**Bulk Recovery Solutions Pty Ltd – Ingleburn Facility – SSD 8593
Additional comments – EPA Air and Noise Technical Advice**

Attachment A

Technical Advice Noise

Technical Advice Air

Figure 2-2 Proposed Site Plan

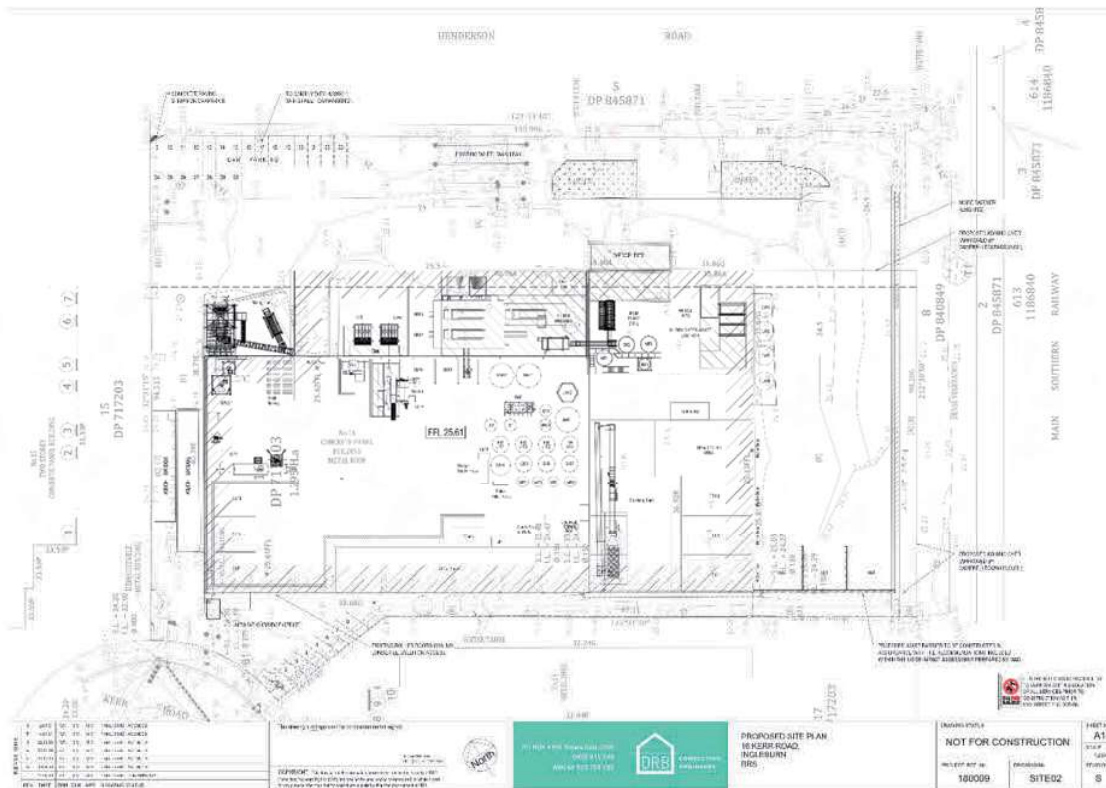
- Clarification of the site layout as the site plan in the noise report is currently inconsistent with the rest of the application.
- Clarification of the operational activities assessed during the day, evening and night periods and confirmation that they are consistent with planned operations.

Figure 6-3 Predicted Noise Contours – Day and Evening Operational Activities

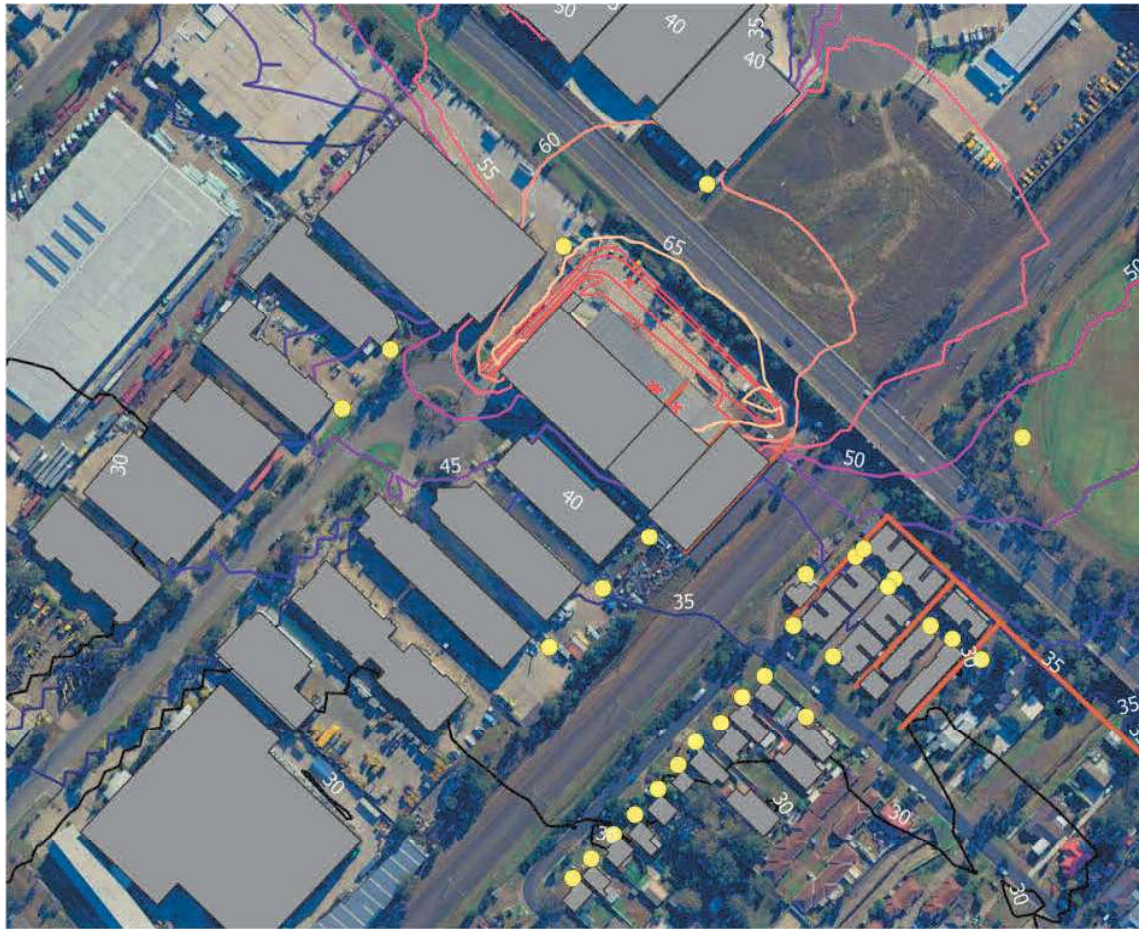
- Noise contour maps to illustrate noise propagation from the premises at surrounding noise-sensitive receivers.
- Justification or reference for the maximum sound power level of L_{max} 102 dBA used in the sleep disturbance assessment, which is less than the $L_{eq,15min}$ level for several of the plant proposed to operate during the night.
